# Planning Services Sign Permit Review Form

Date of Submittal	Application Number	Applicant	Landowner
Revised Plans submitted 5/19/2021	SIGN2105-0006	Commercial Permit Expediting, LLC	PTM LP

Contact Person	Contact Number	Sign Location	PIN Number
Jennifer Bardeschkeski	919-395-6959	2 signs located on NC HWY 87 N	9594-26-1847.000

PS2

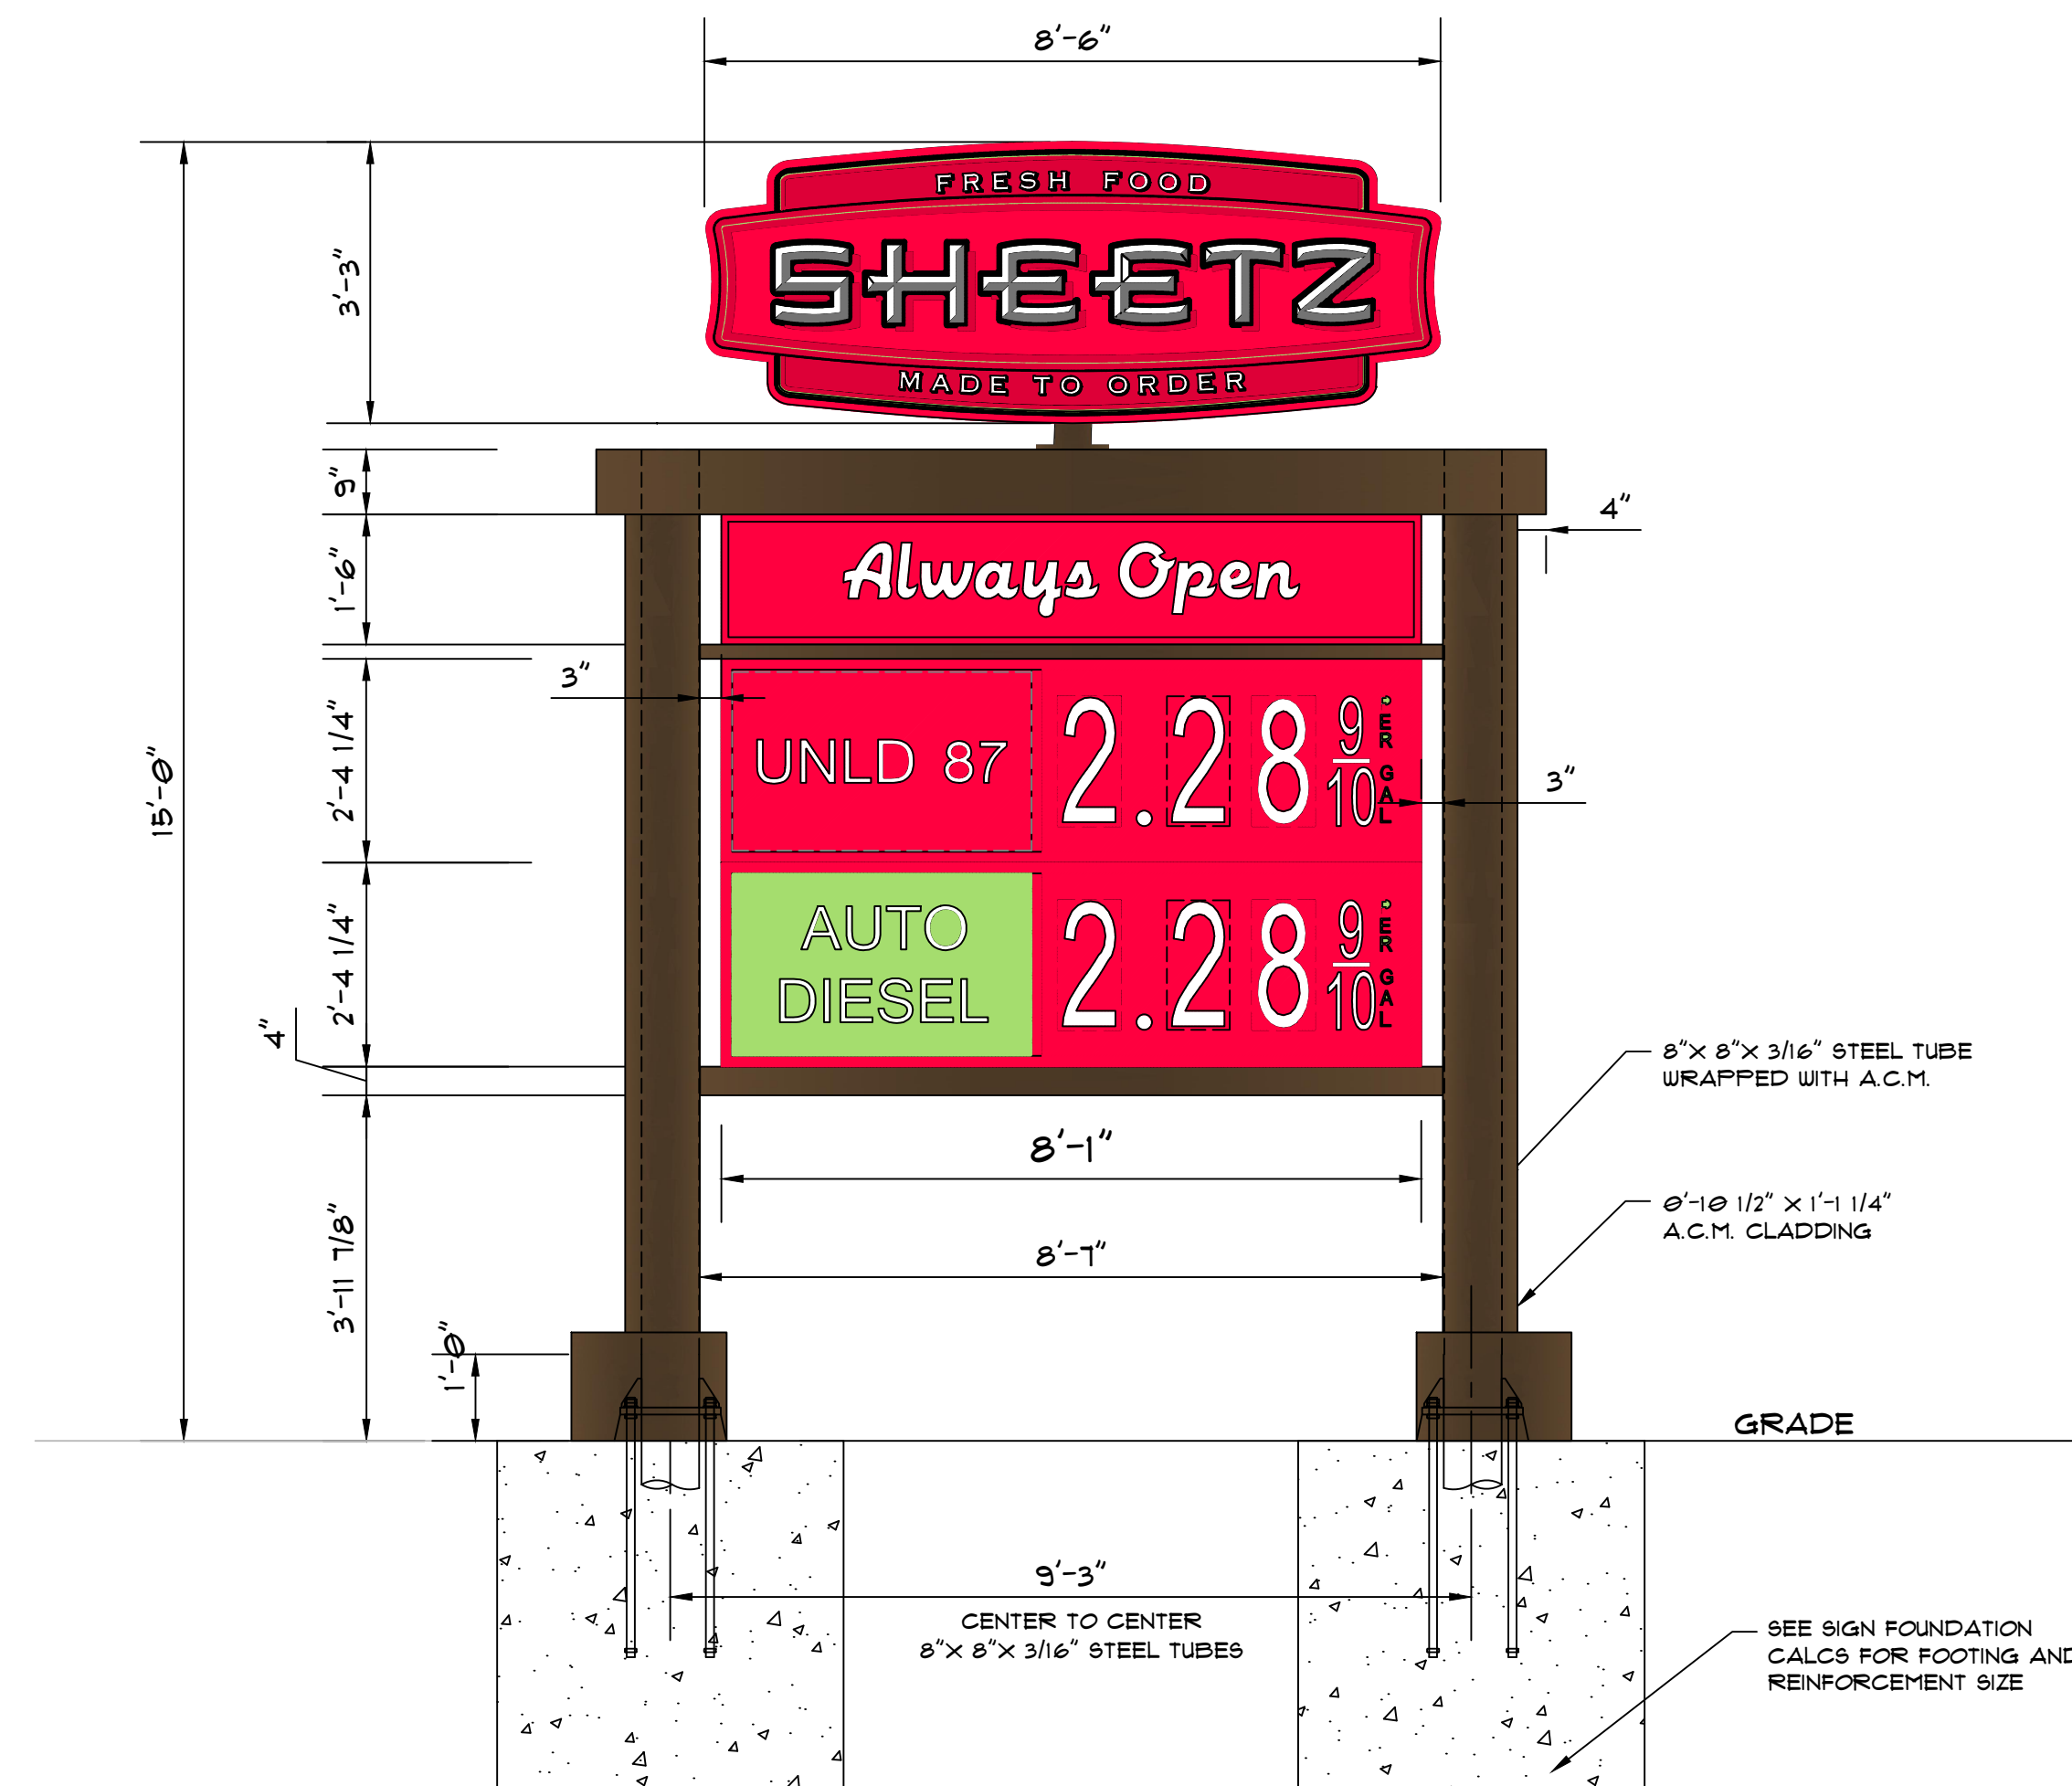
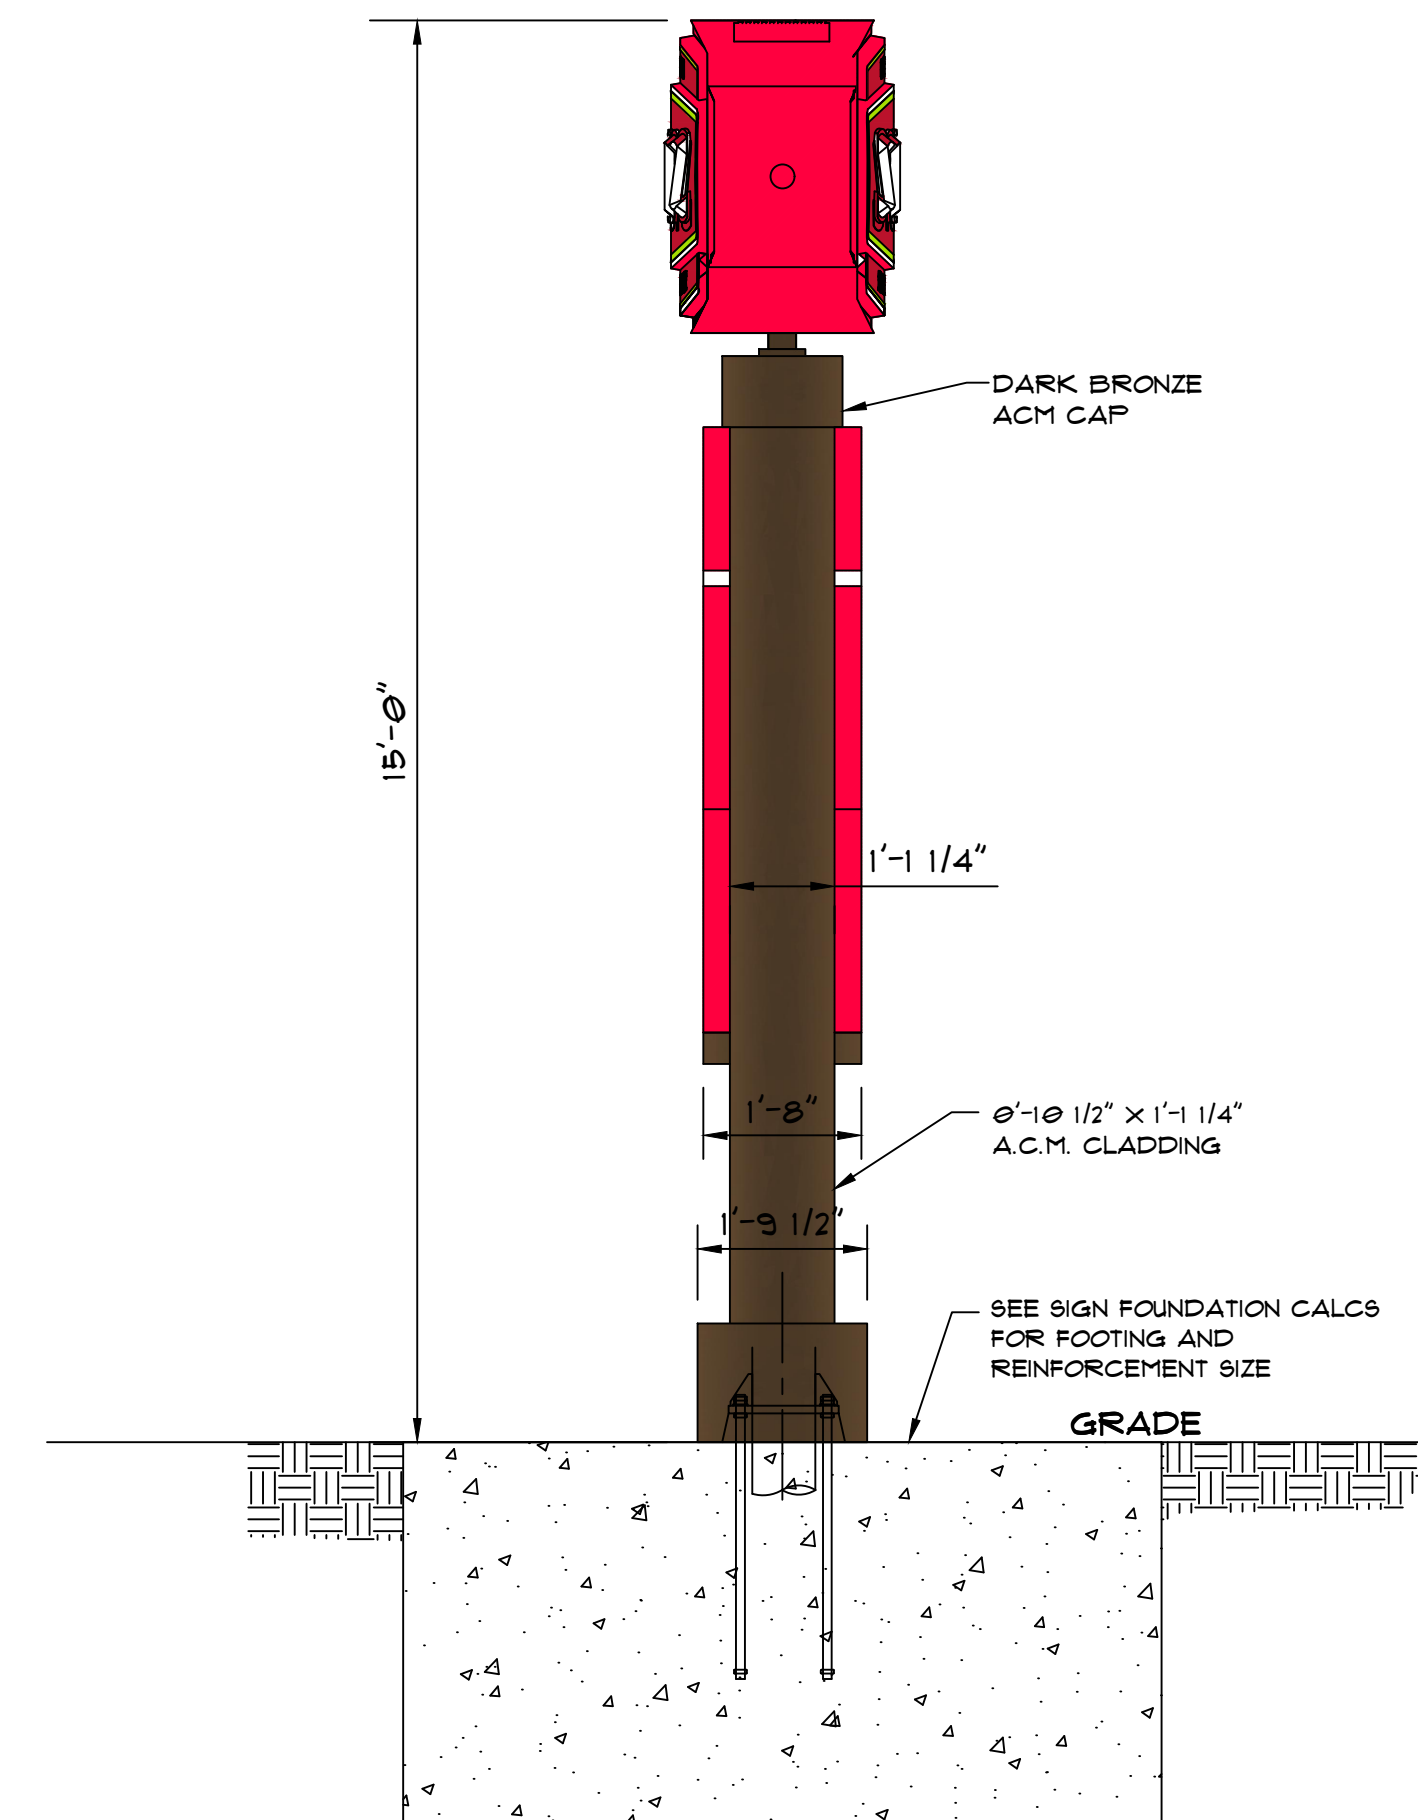
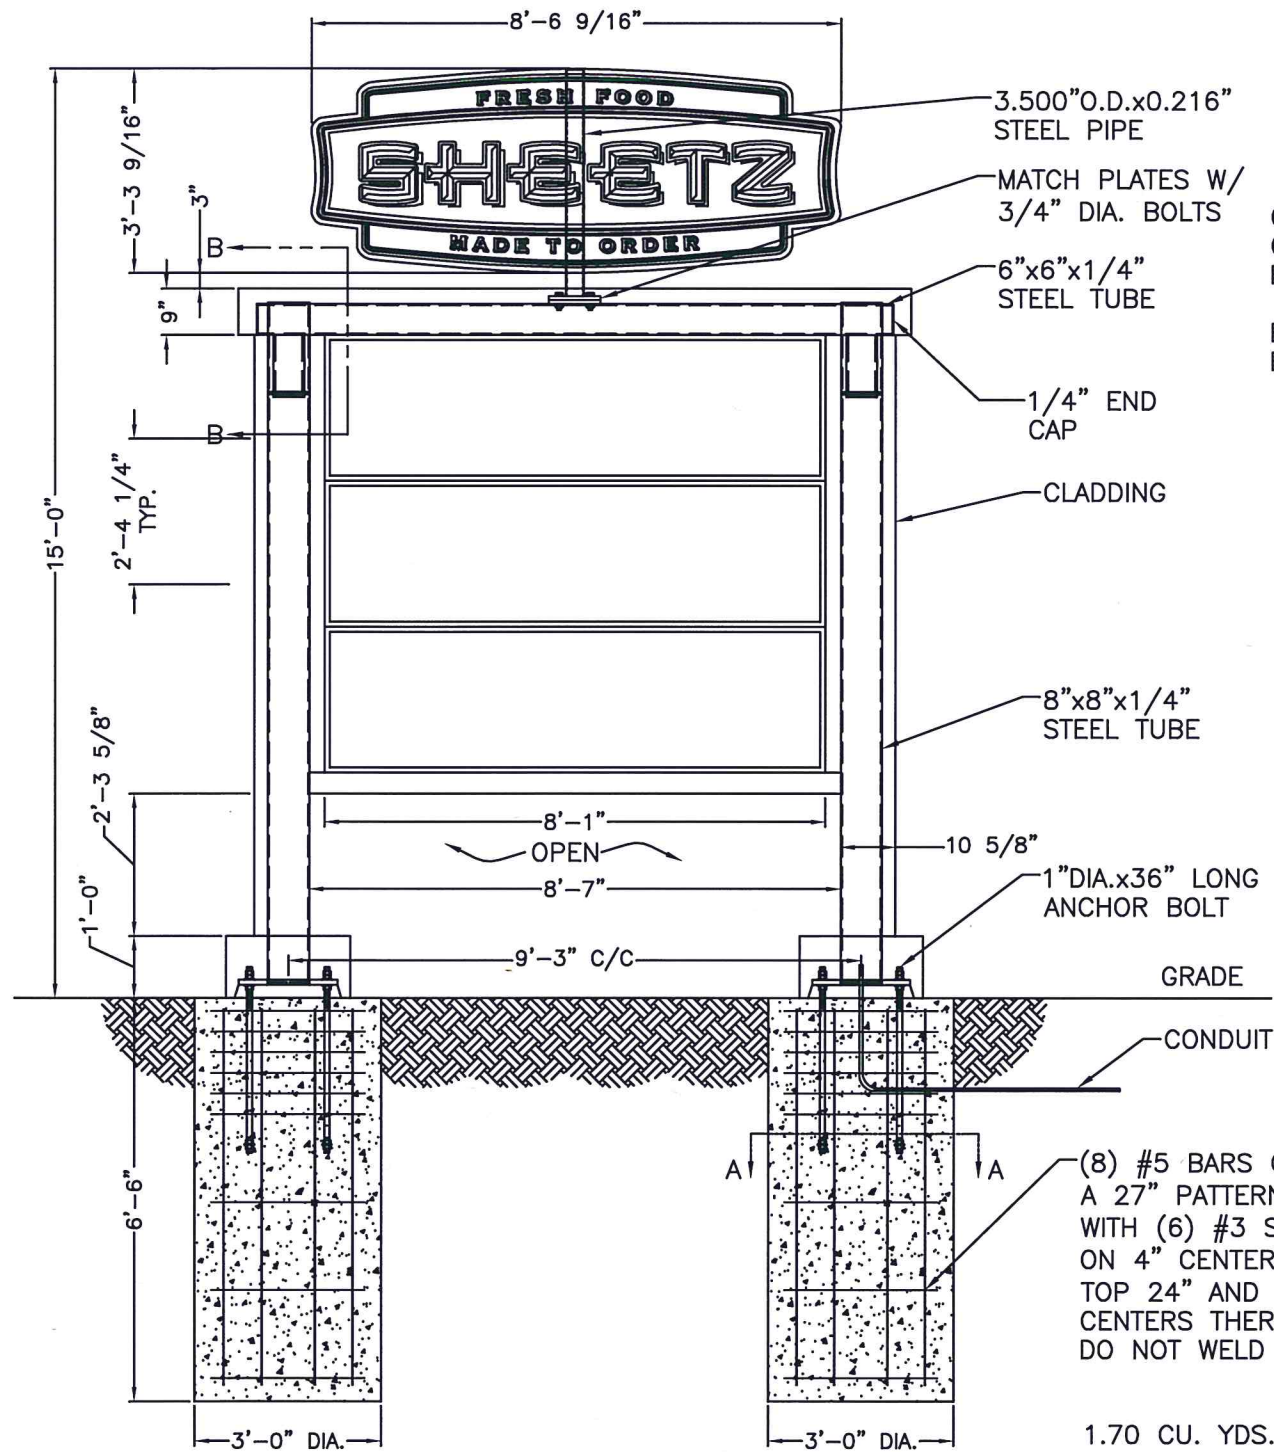
Comments	<p>Please see site plan, sign plan, and UDO code below.</p> <p><b>B. Said sign shall be constructed of an external support structure including stone, brick, ornamental metal or similar materials, provided that the maximum number of supports, uprights, bracings, or frameworks extending between grade and the base of the sign face shall not exceed two (2).</b></p>
----------	---
